Our Ref: BR/100/18/HH
Your Ref:

Town & Country Planning Act 1990 (as amended)
Town & country Planning (Development Management Procedure) (England) Order 2015
Application for Planning Permission for Works or Extension to a Dwelling

Development Detached double garage & detached single garage within the curtilage of a single dwelling unit.
Location 33 Tennyson Road Bognor Regis

DRAWING TITLE
BLOCK PLAN

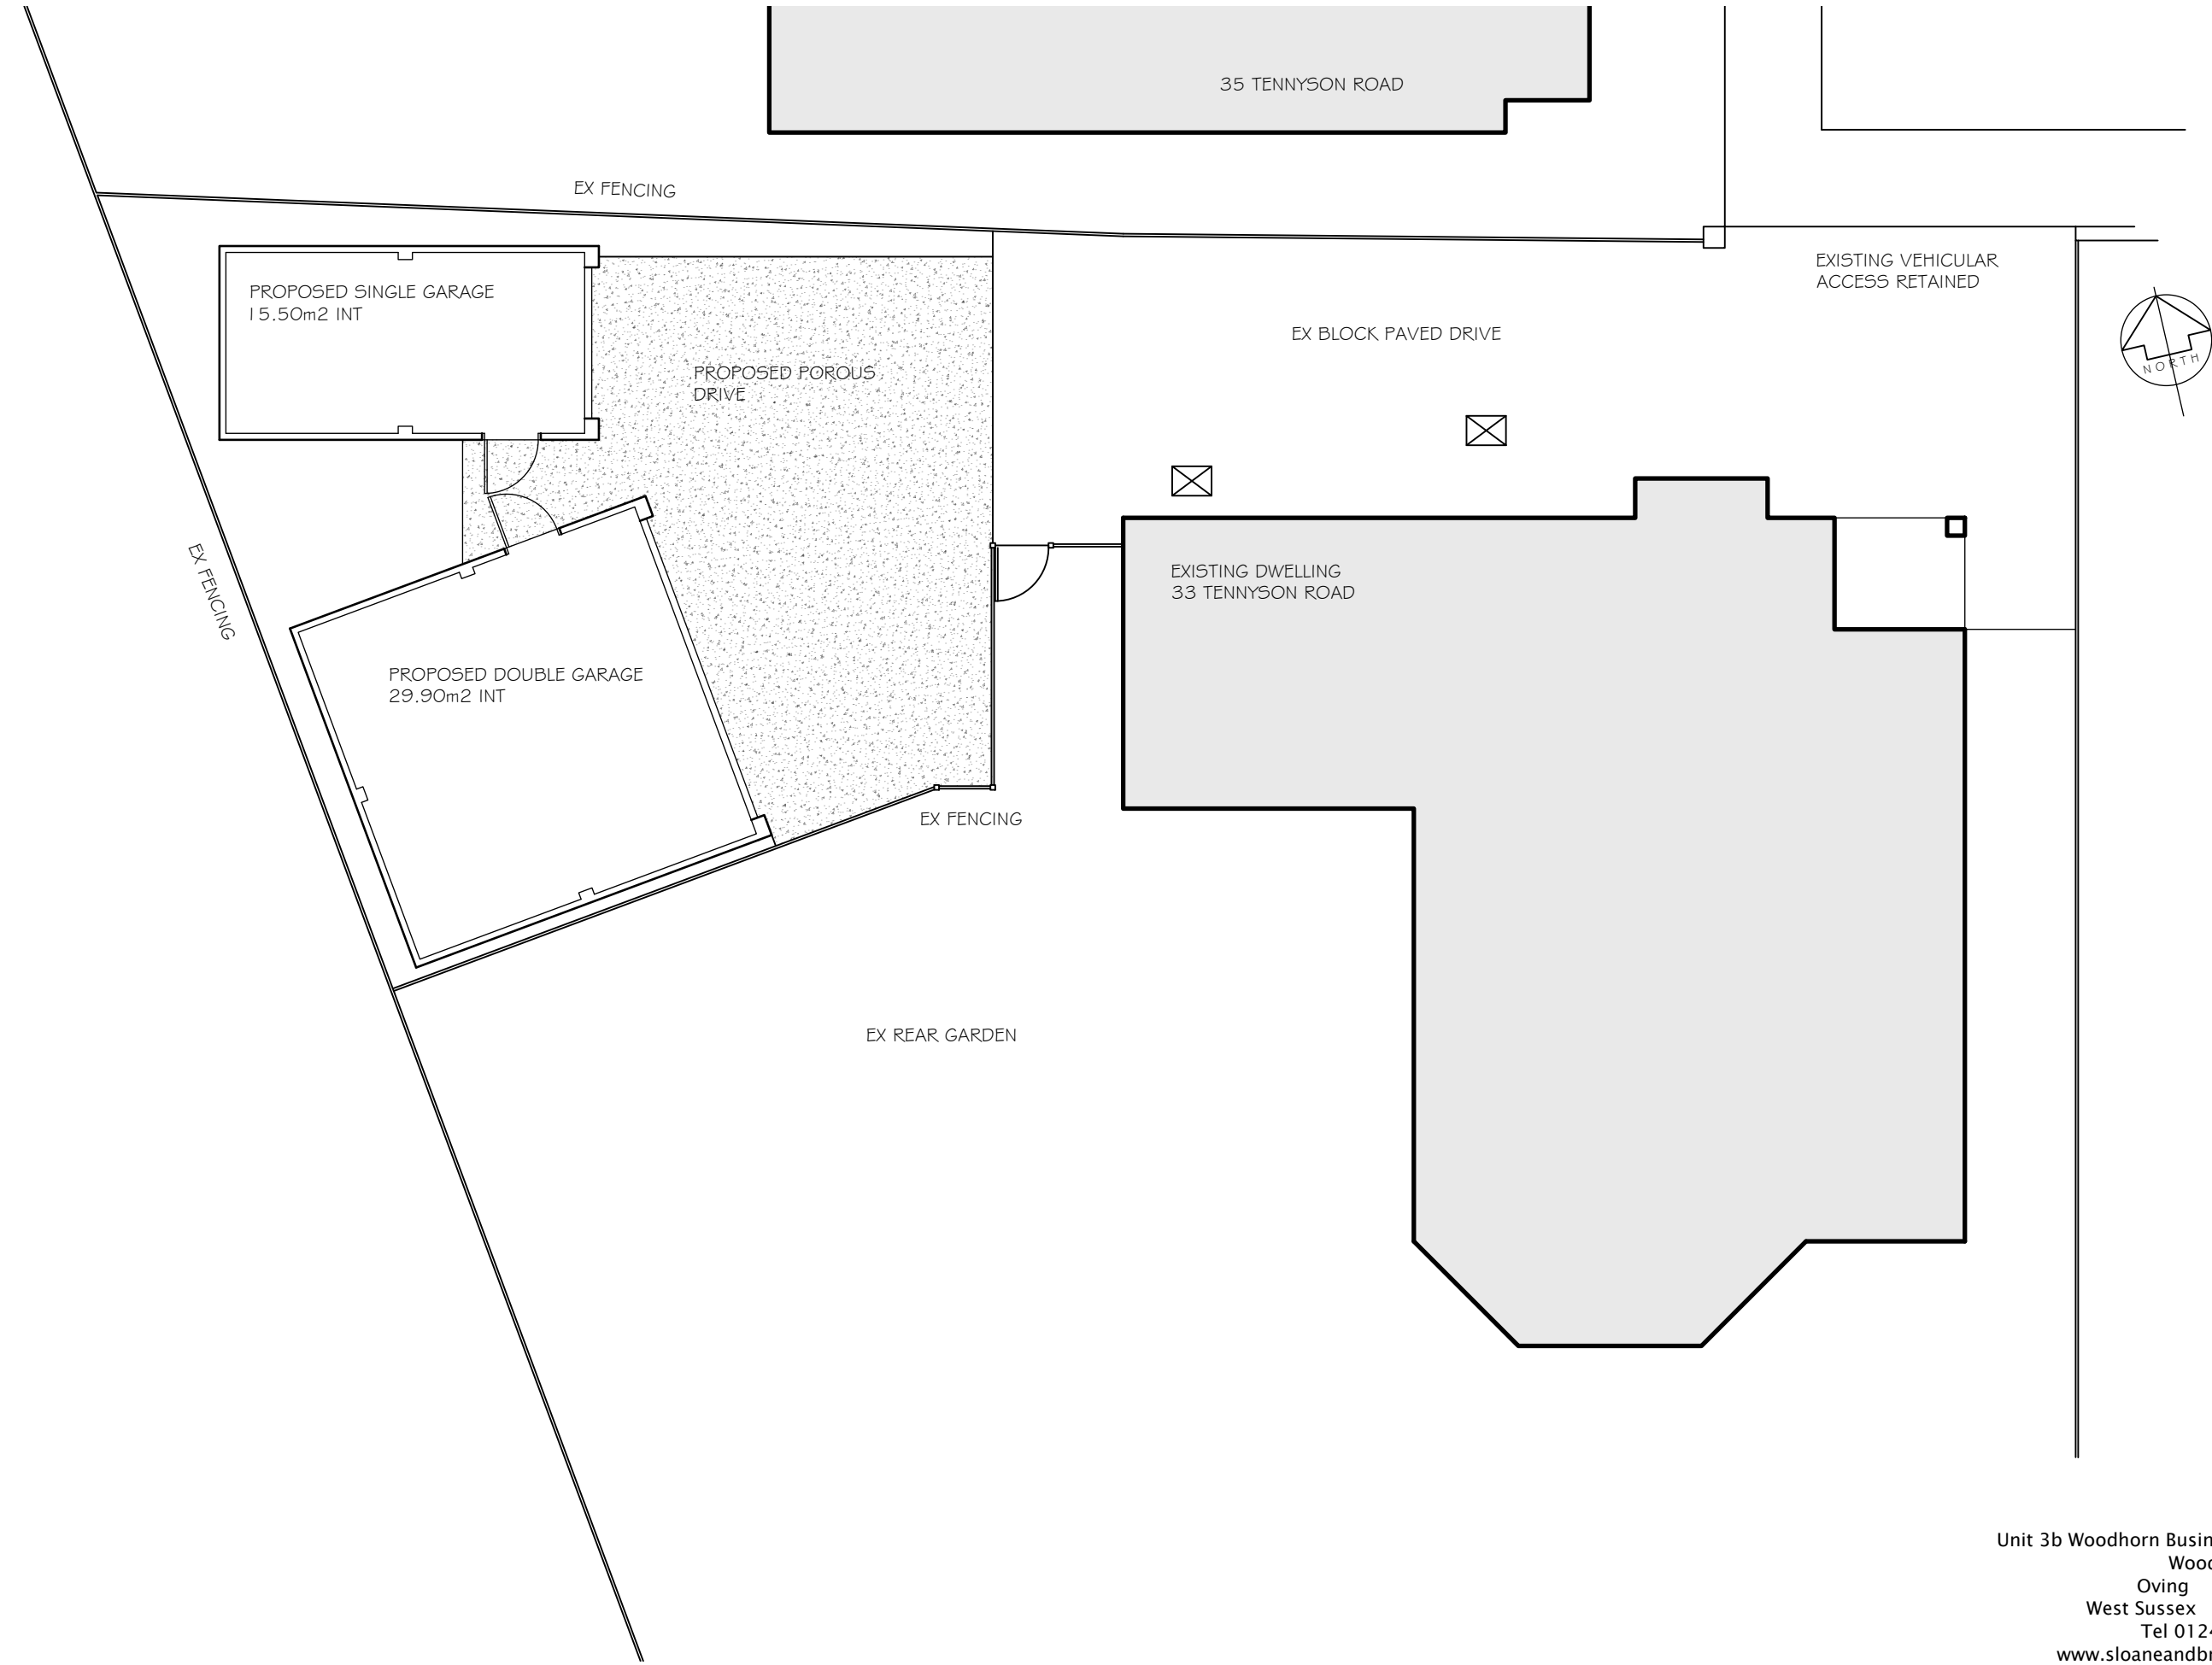
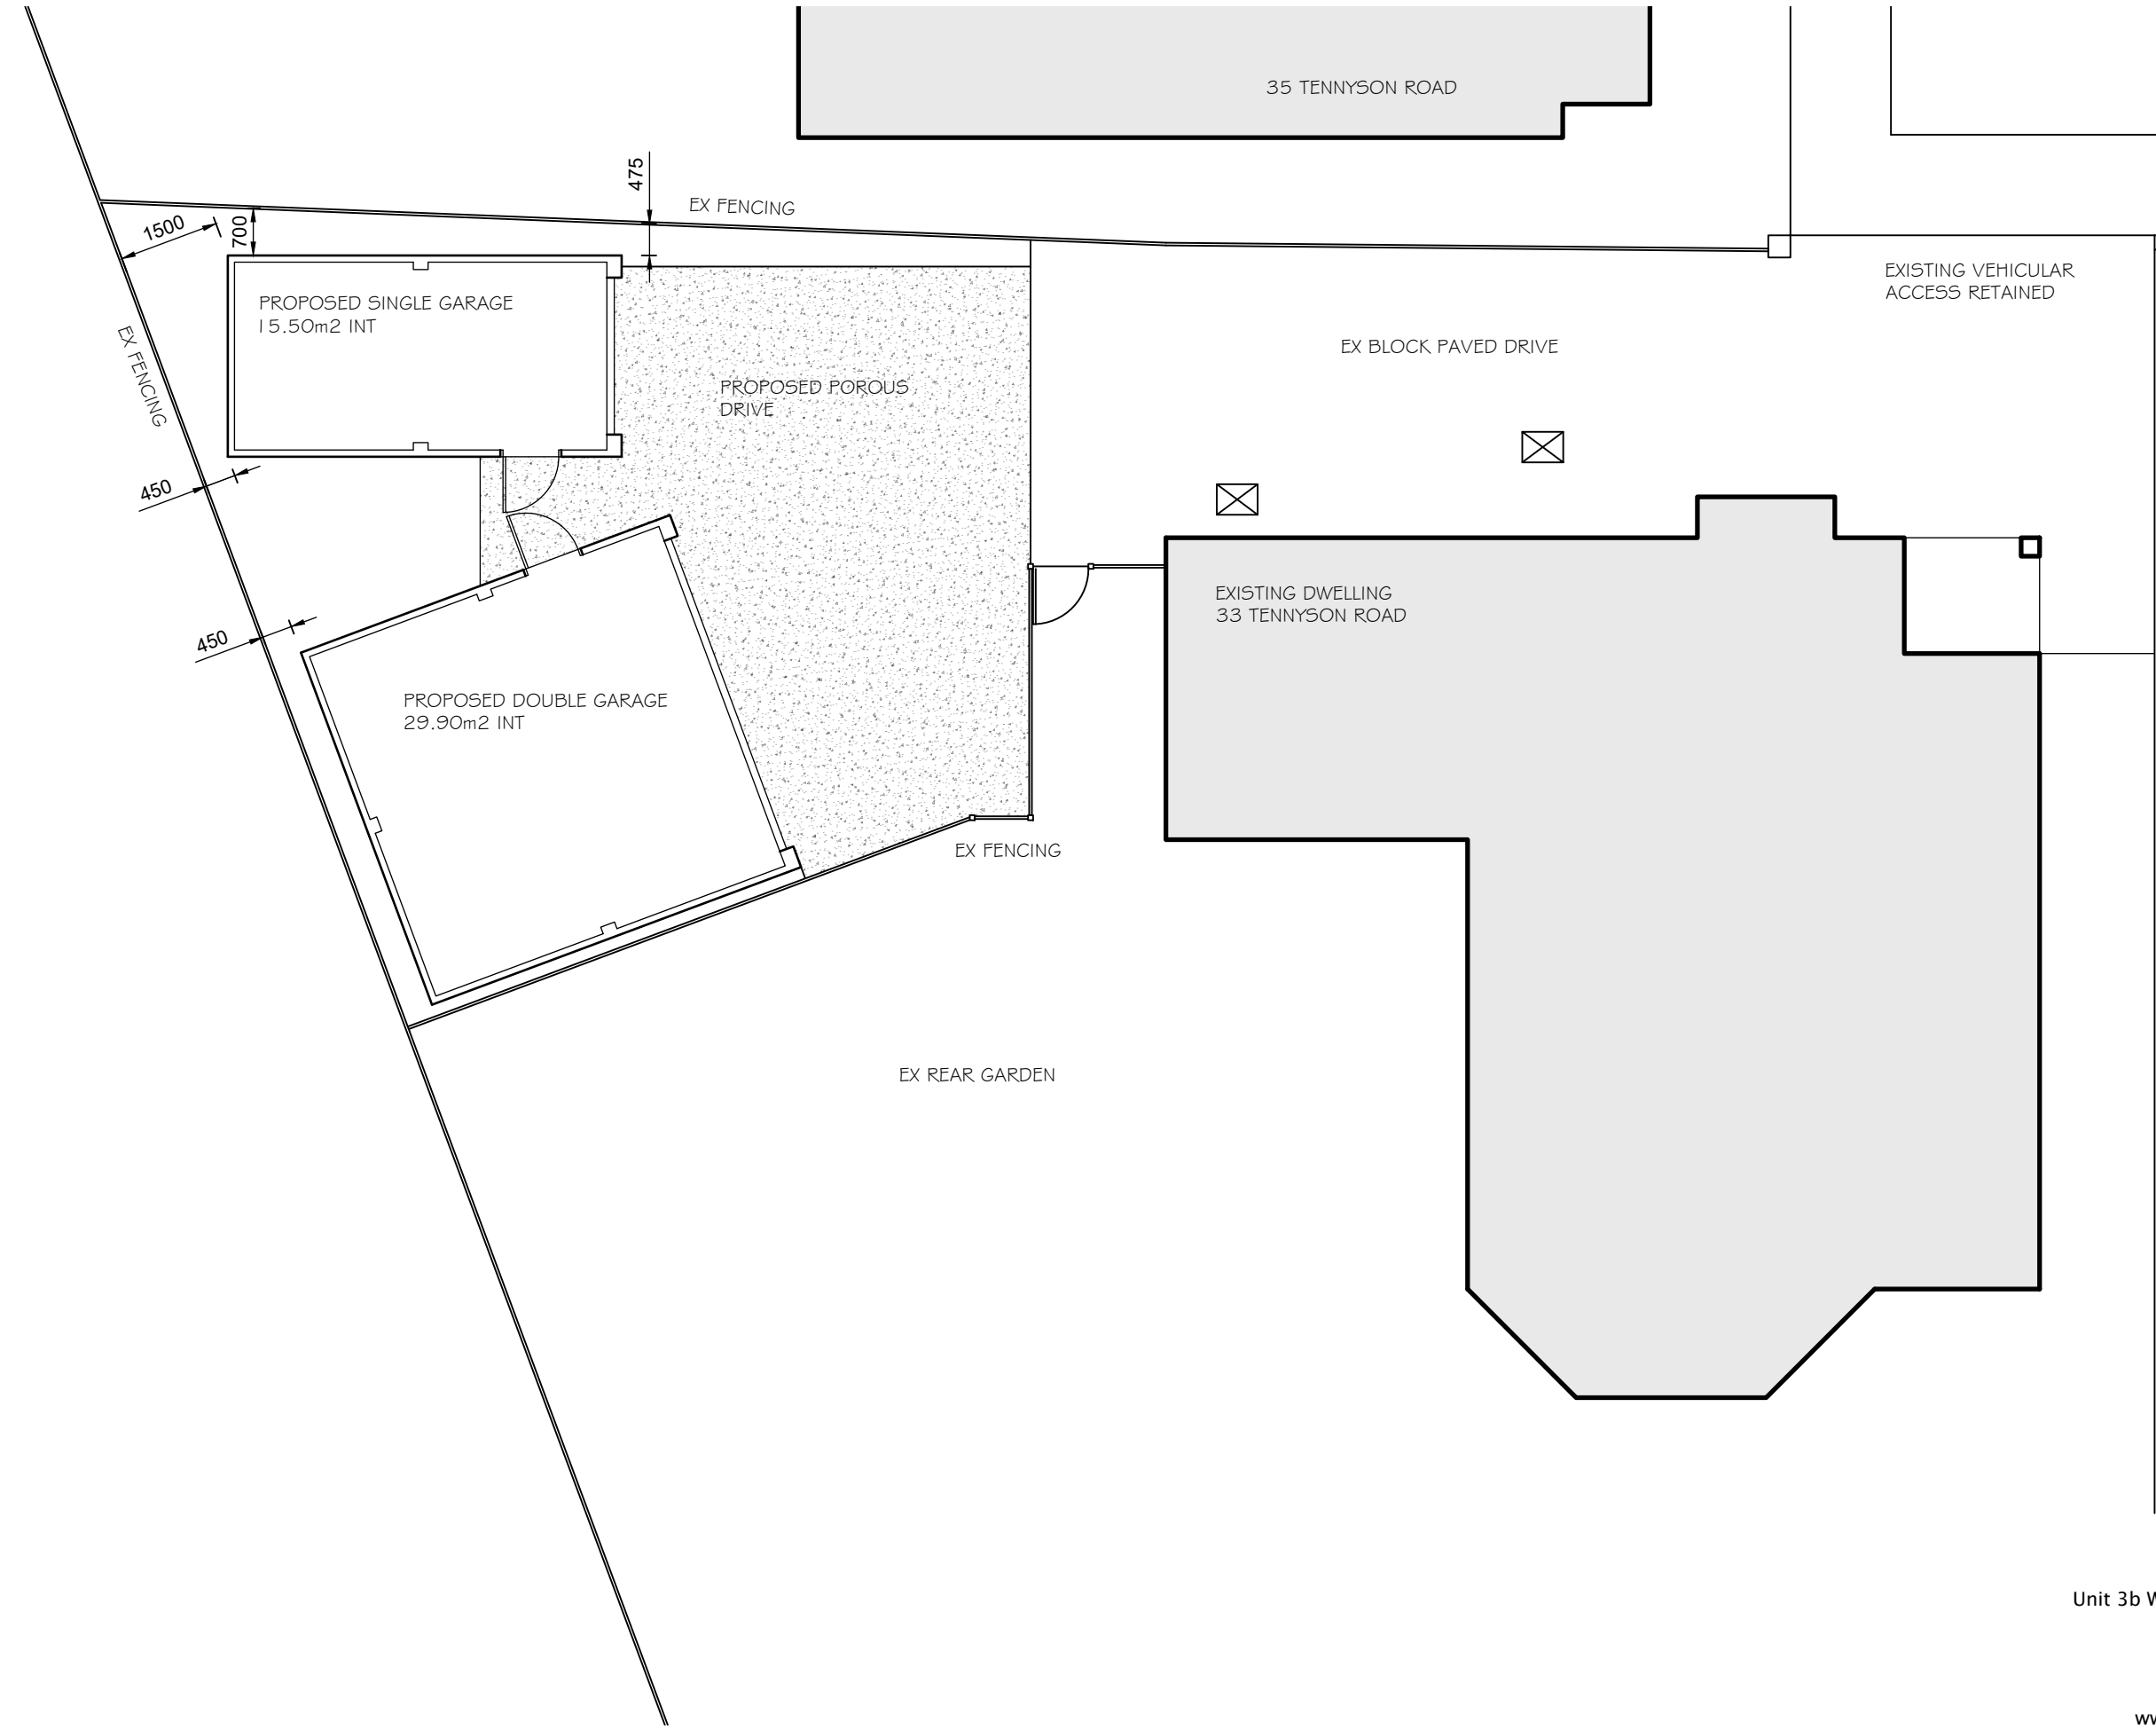
Block Plan

Please submit 1 electronic or 3 paper copies of an amended block/site plan at a scale of 1:500 or 1:200 showing the measurements to the boundaries
